September 28, 2022

Reference: New Mexico Proton Advanced Cancer Therapy (NMPACT)
Response to Development Review Board Planning – Case Comments
Project: PR-2022-007588
Application: SI-2022-01658

A7 SOUTH ELEVATION
1/8" = 1'-0"

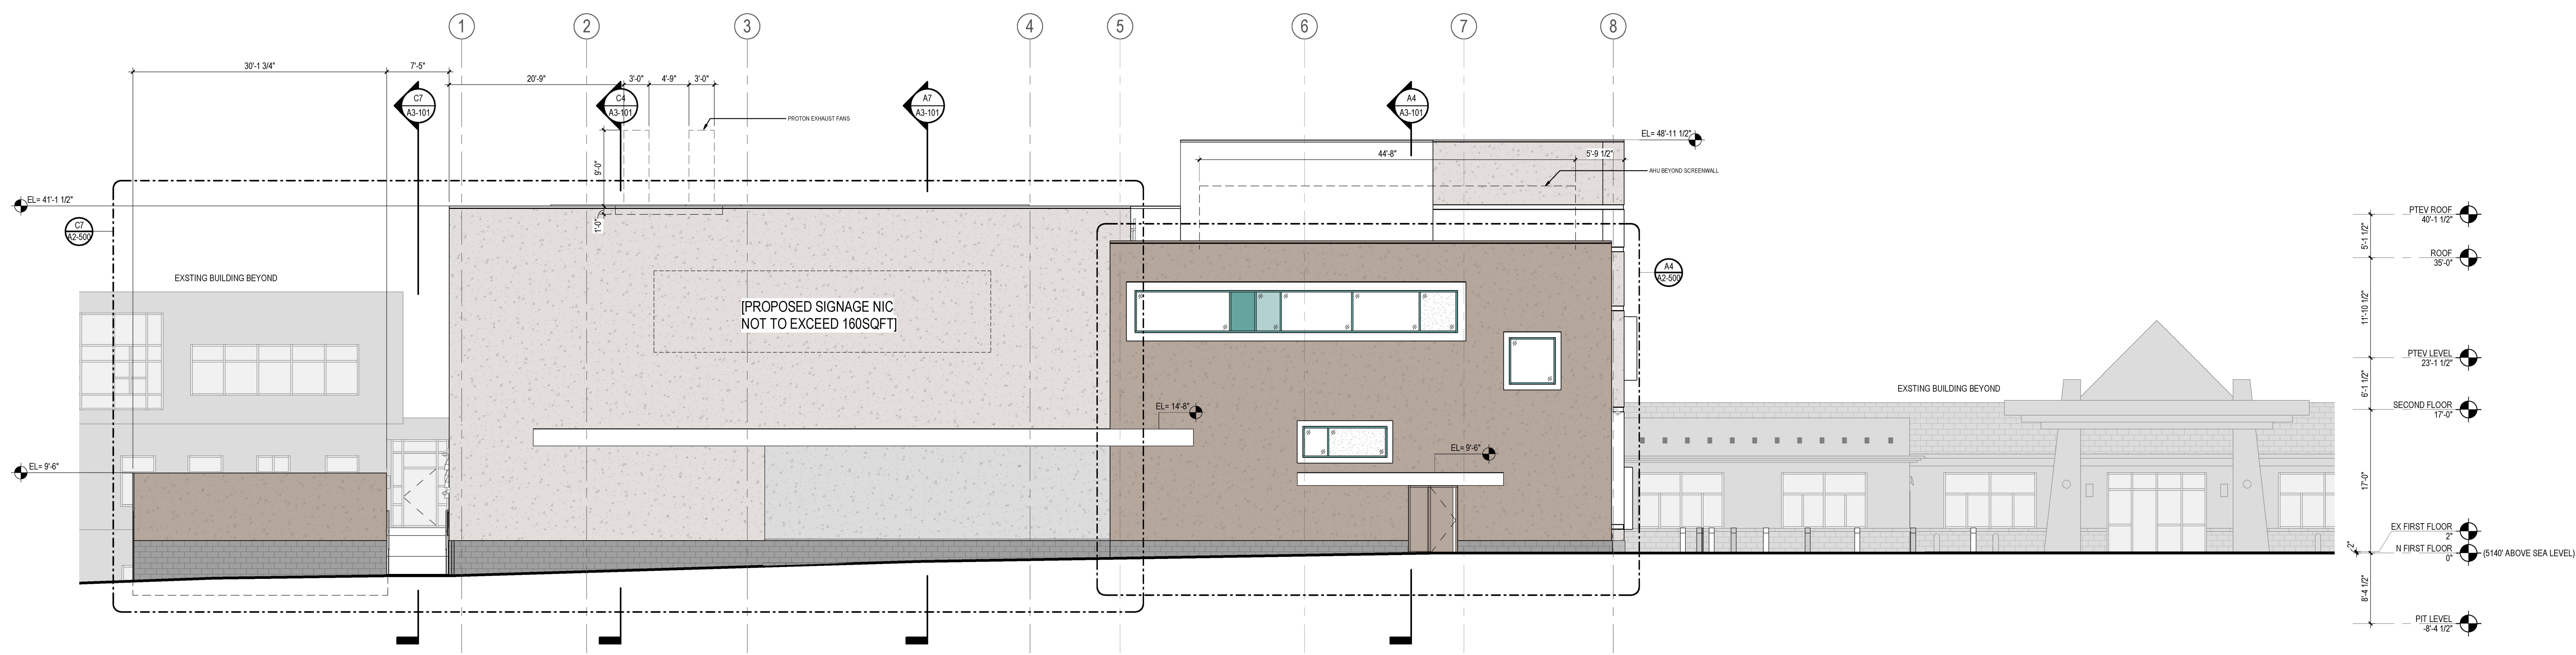
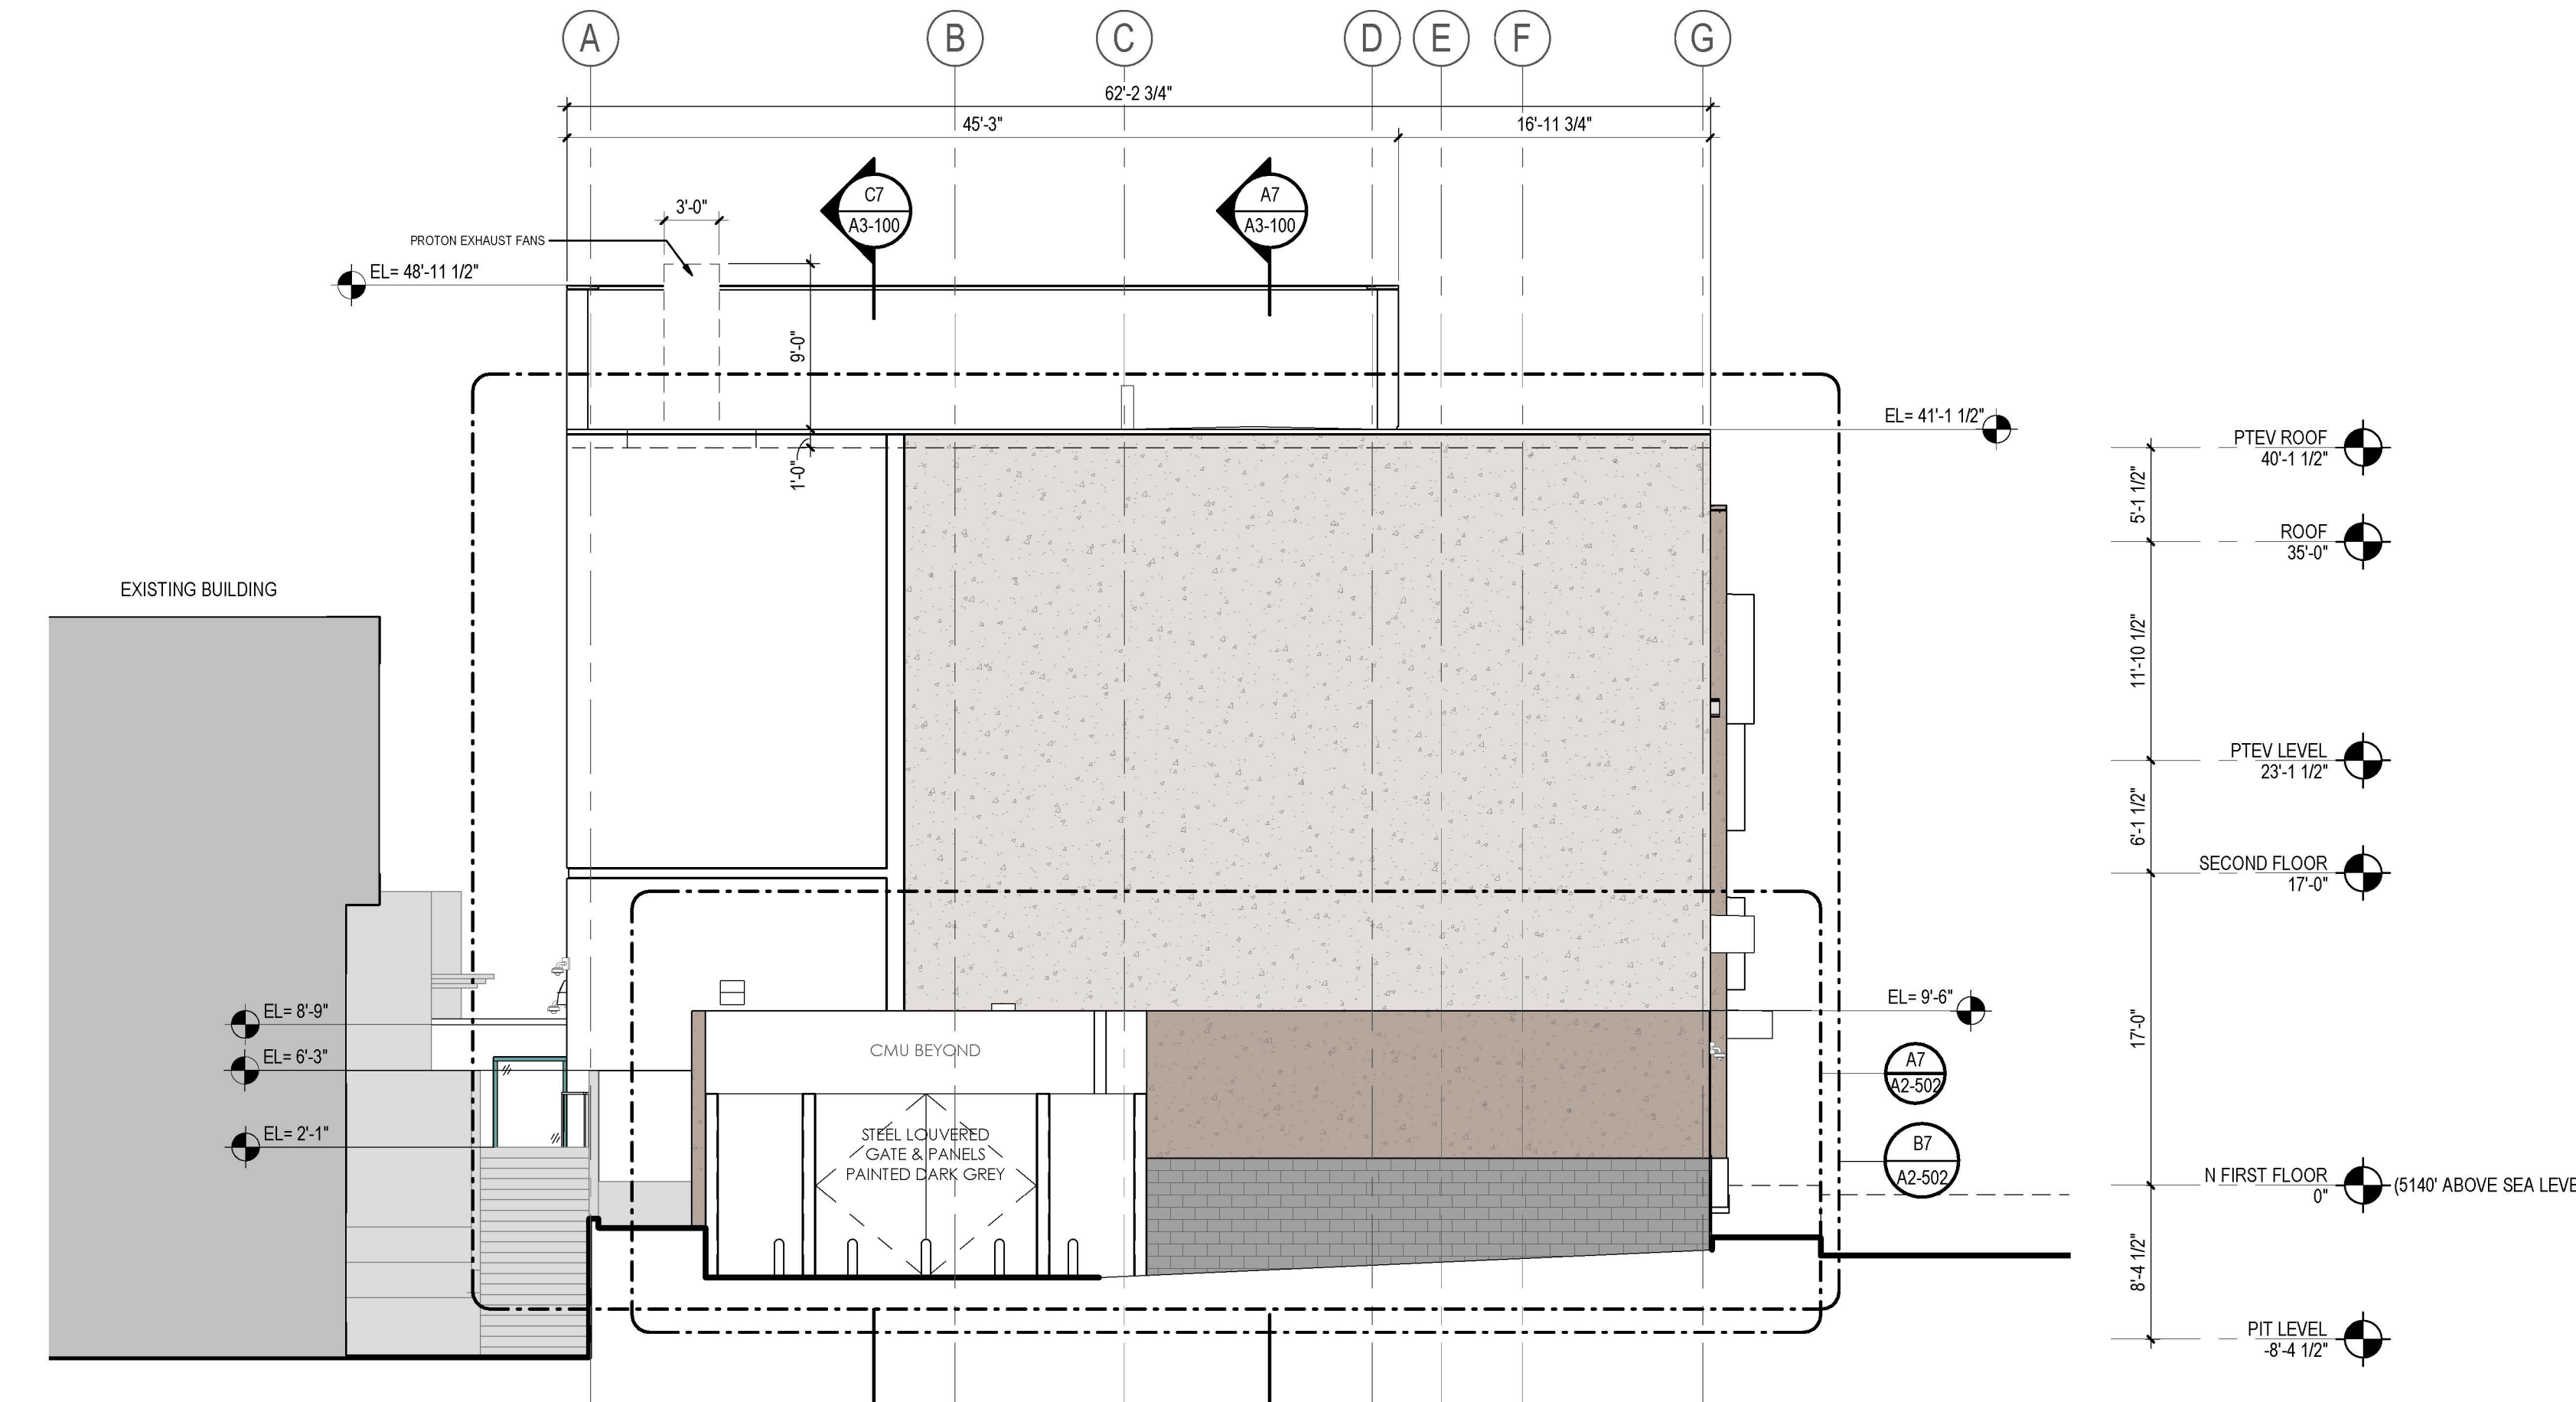
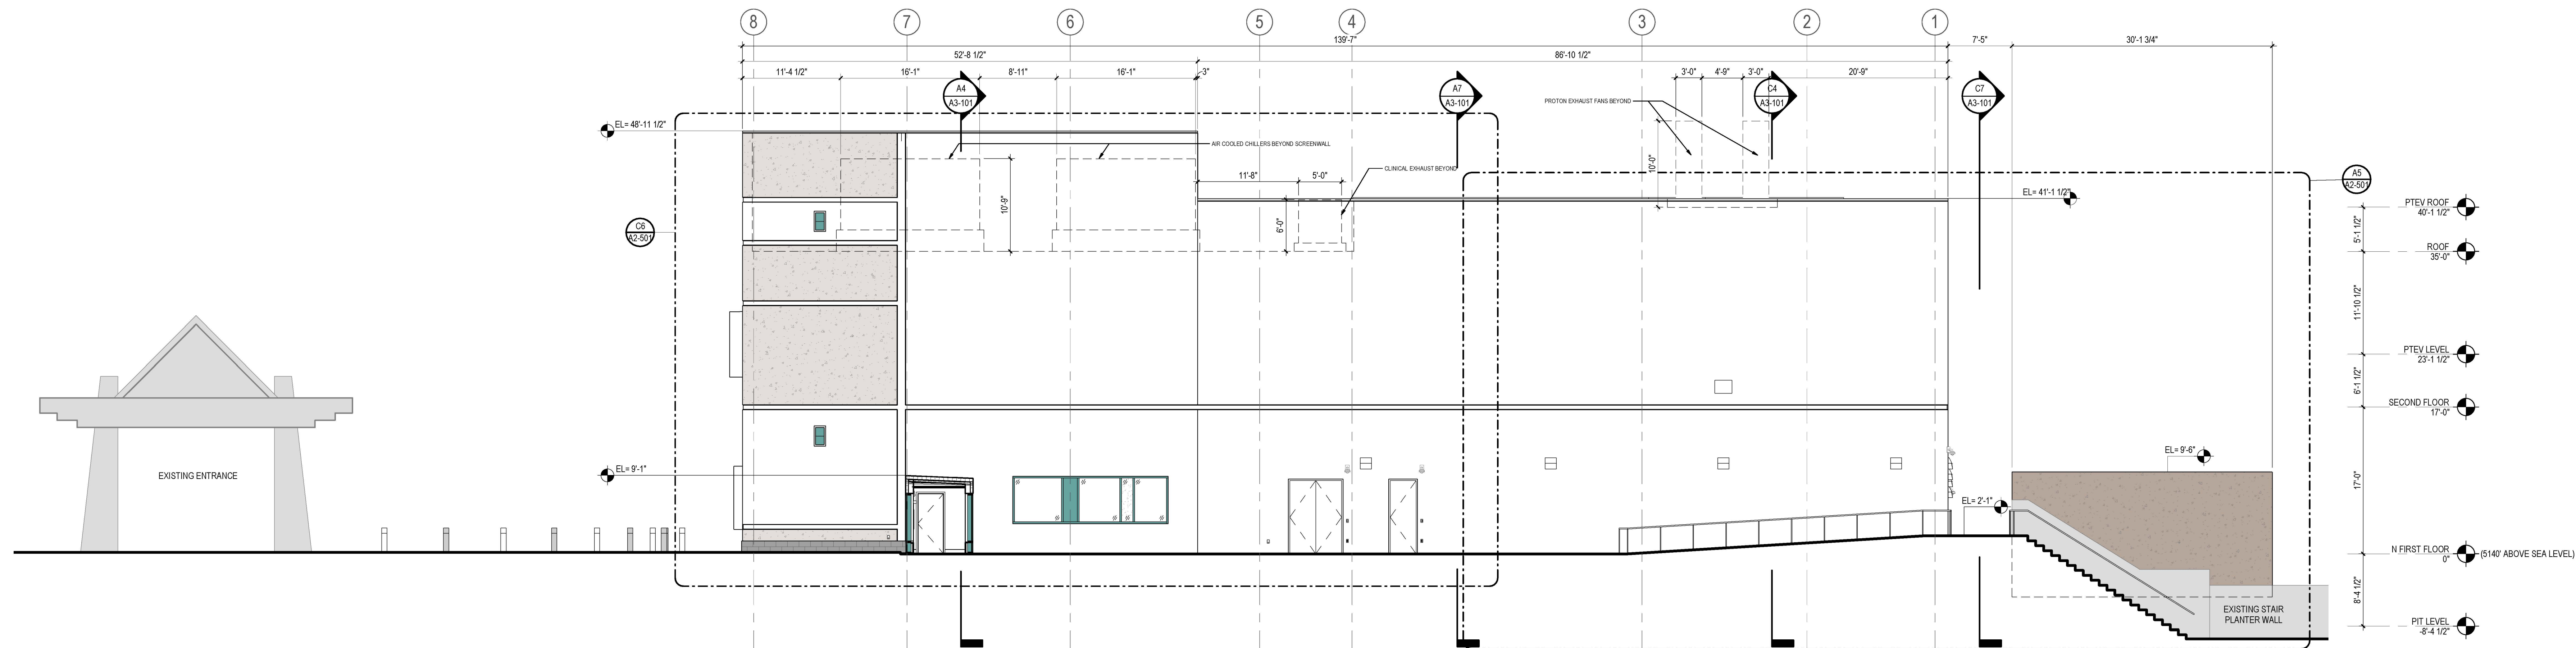
- a. *Stantec Response: Please confirm that the compliance issue is the same one identified below in Planning comment 3.*
3. The applicant must provide proof how the building/façade design requirements are being met per 5-11 (E) of the IDO as notes on the amended Site Plan and/or in a comment response letter.

- ii. 5-11 (E)(2)(a)(2). *The street-facing façade (south elevation) incorporates two features. Specifically:*
 1. *Item (b). Windows on upper floor. There are two windows on the second floor and their combined length exceeds 30% of the façade length. The windows combine for 44 feet and the façade is 140 feet. $44/140 = 31\%$ of the façade. See attached project rendering and Building Elevations, Sheet A2-100.*

2. *Item (d). Elements that provide shade or protection from weather. There are two sunshades, and their combined length exceeds 30% of the façade length. The element also occurs more frequently than every 40 feet. The sunshades combine for 100 feet and the façade is 140 feet. $100/140 = 71\%$ of the façade. See attached project rendering and Building Elevations, Sheet A2-100.*

- iii. 5-11 (E)(2)(a)(3). *The street-facing façade (south elevation)- longer than 100 feet - incorporates more than one required feature. Specifically:*

1. *Item (c). Offset or projecting element. There is a niche that is 3'6" offset from main façade plane that is 30% of the façade length. Additionally, there are two sunshades that project more than 6" from the façade and cover 71% of the façade. See attached project rendering.*

2. *Item (f). Art. There is an 11-foot high by 42-foot-wide section of the façade (at ground floor) that is designated for an Owner-furnished tile mural. See attached project rendering.*
